## PLANNING CONSULTATION RESPONSE

<b>Application No</b>	2025/0787
<b>Proposal</b>	Single storey front extension, formation of driveway and installation of dropped kerb to front of dwelling.
<b>Address</b>	16 Haigh Lane, Hoylandswaine, Barnsley, S36 7JJ
<b>Date of Consultation Reply</b>	28 <sup>th</sup> November 2025
<b>Consultee</b>	Highways DC

Proposed Plans and Elevations

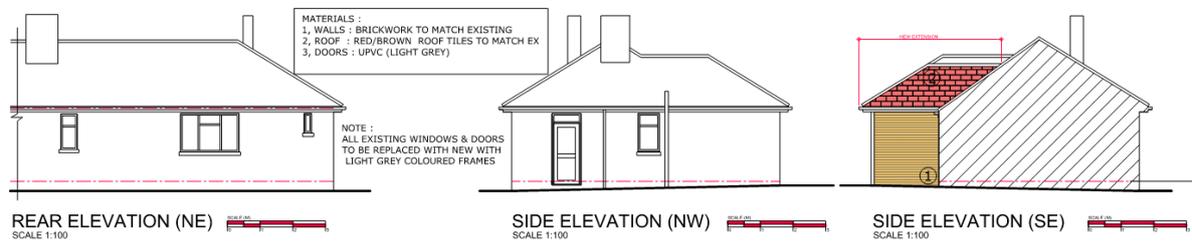
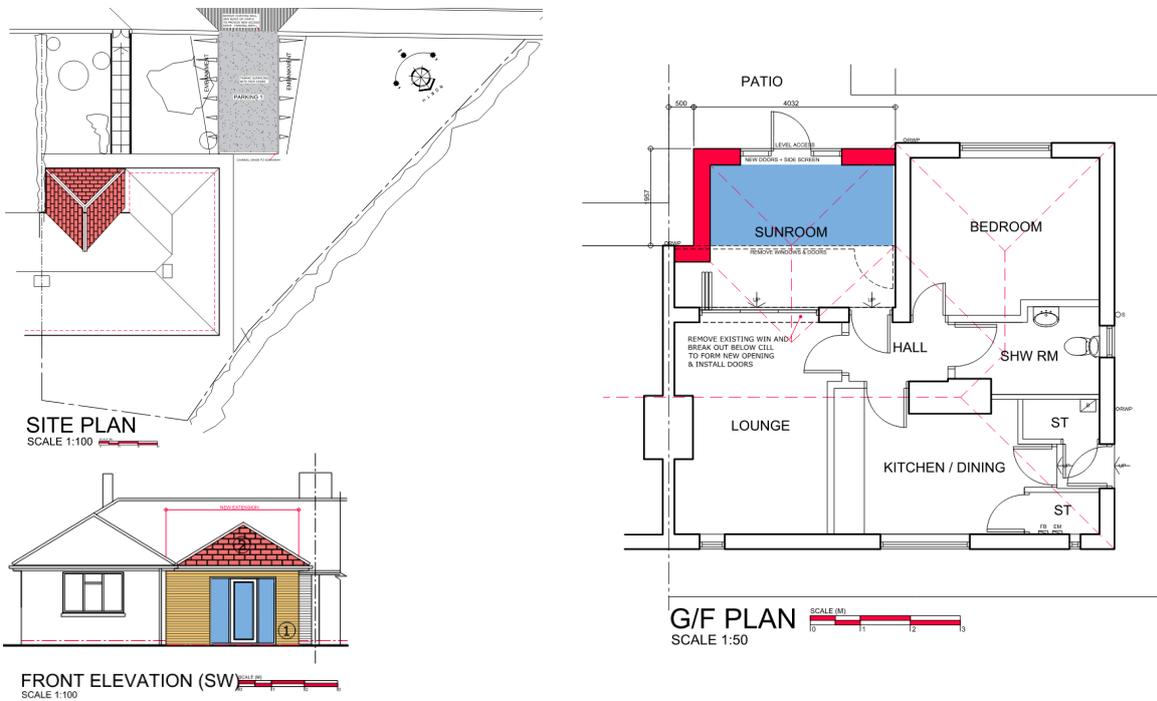
Due to the ample footway width and generous 25m wide site frontage with a low boundary wall, the required 2.4m x 43m sight lines are achievable from the proposed access.

Given that Haigh Lane is classified (C155) there is a general requirement for vehicles to enter and exit in a forward gear in the interests of highway safety, however, there are a number of properties within the vicinity of the site that have frontage parking areas/driveways with no turning provision, in this regard a precedent has already been set.

Considering the local context, on balance it is viewed as being less detrimental to highway safety to have a vehicle associated with this property reversing to/from a frontage parking space than it is to have the vehicle parked on-street.

The proposals include a driveway of adequate size to accommodate a single vehicle; the site layout plan indicates that the driveway is to slope into the site and would therefore drain away from the public highway.

The access and parking facility, indicated on the submitted plan, shall be surfaced in a solid bound material (i.e. not loose chippings) and made available for the access and parking of motor vehicles and shall be retained for said purposes at all times. Adequate measures shall be so designed into the proposed vehicular area to avoid the discharge of surface water from the site on to the highway.

The gradient of areas for vehicular and pedestrian use shall not exceed 1 in 12.

Sight lines, having minimum dimensions of 2.4m x 43m, shall be safeguarded at the access junction with Haigh Lane, such that there is no obstruction to visibility at a height exceeding 0.9m above the nearside edge of the adjacent highway. Nothing shall be erected, retained, planted and/or allowed to grow at or above a height of 0.9m which would obstruct the sight lines and they shall be maintained free of obstruction at all times thereafter for the lifetime of the development.
